WISWELL PARISH COUNCIL

Planning Application No: 3/2012/0623

Outline application with all matters reserved for residential development of 23 dwellings with access, parking and associated landscaping following demolition of nos 23 and 25 Old Row

Land at 23-25 Old Row, Barrow, Clitheroe, Lancashire

PROPOSED SITE LAYOUT

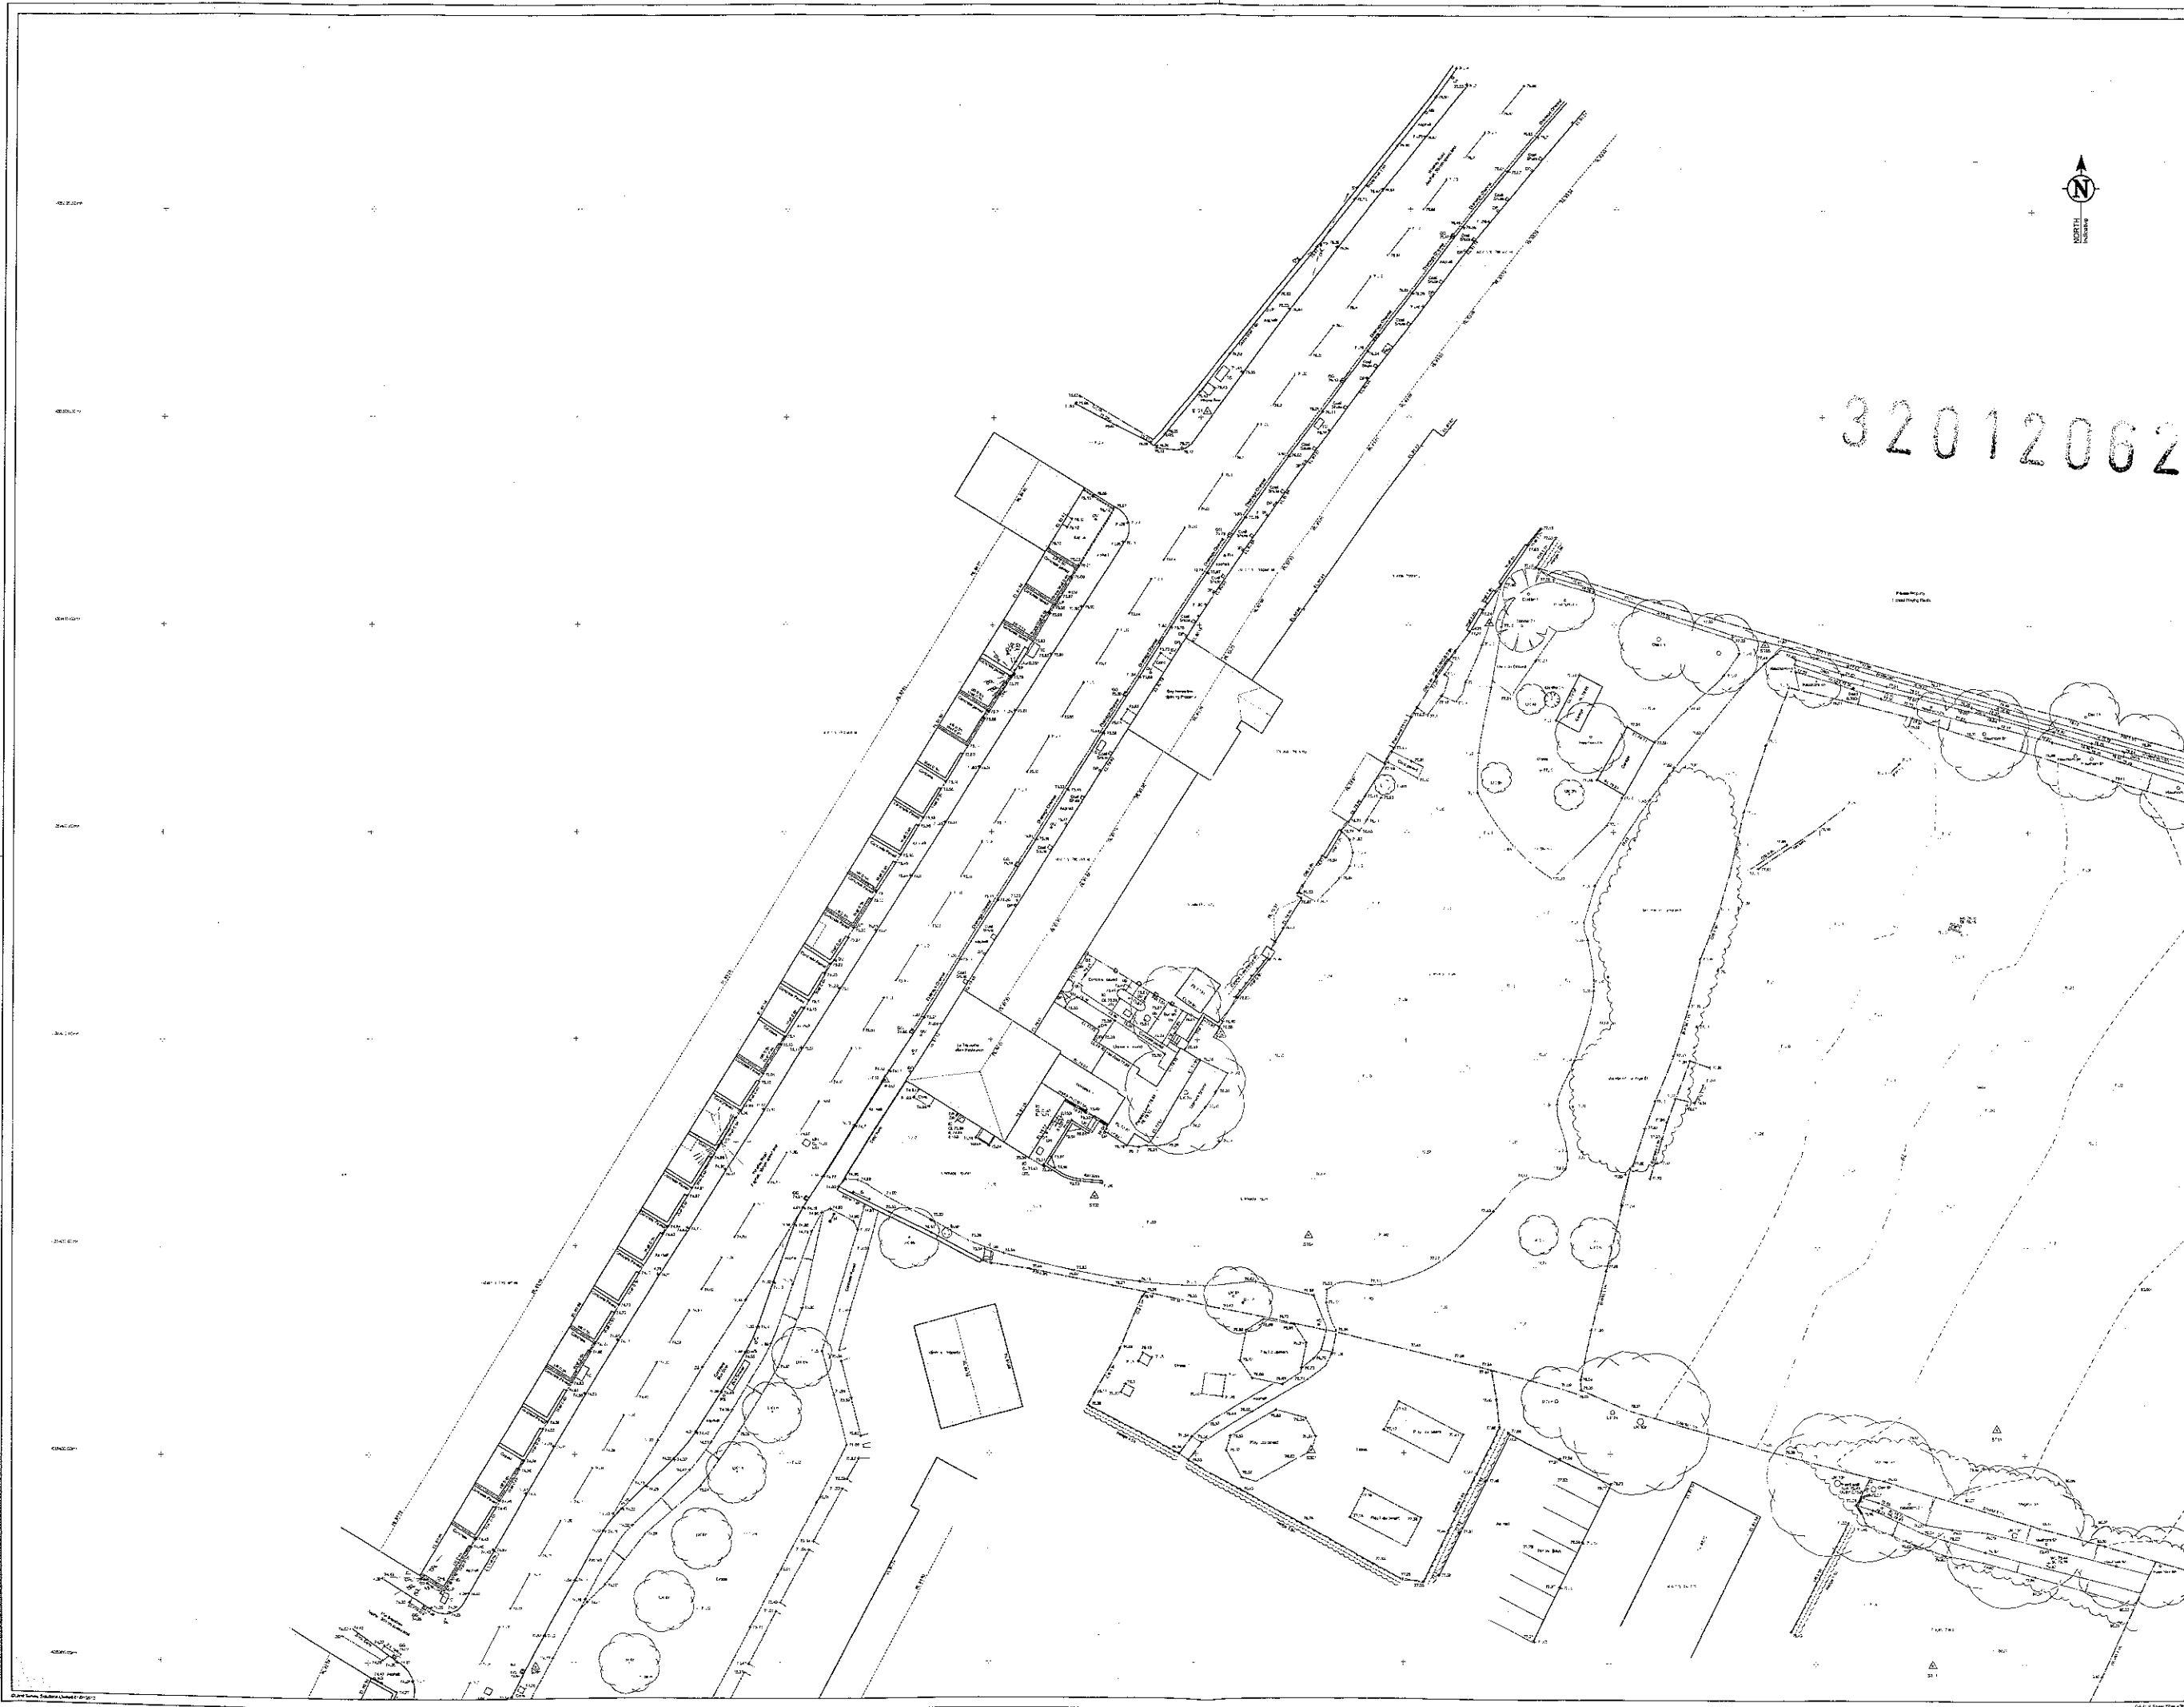
8. Part of the proposed site has been incorporated into the Printworks site. As recommended by ICC Highways Department, could this development be accessed via the roundabout on the A59 rather than from Whalley Road? A similar plan was approved for the nearby Barrow Brook development and this has been successful in limiting traffic congestion.

1. A public footpath runs through the site and this must be maintained and protected.

1. The Parish Council welcomes the proposed parking allocation at the rear of Old Row for existing properties and if the application is approved, recommends that the provision is included within a legal document (s106 agreement).
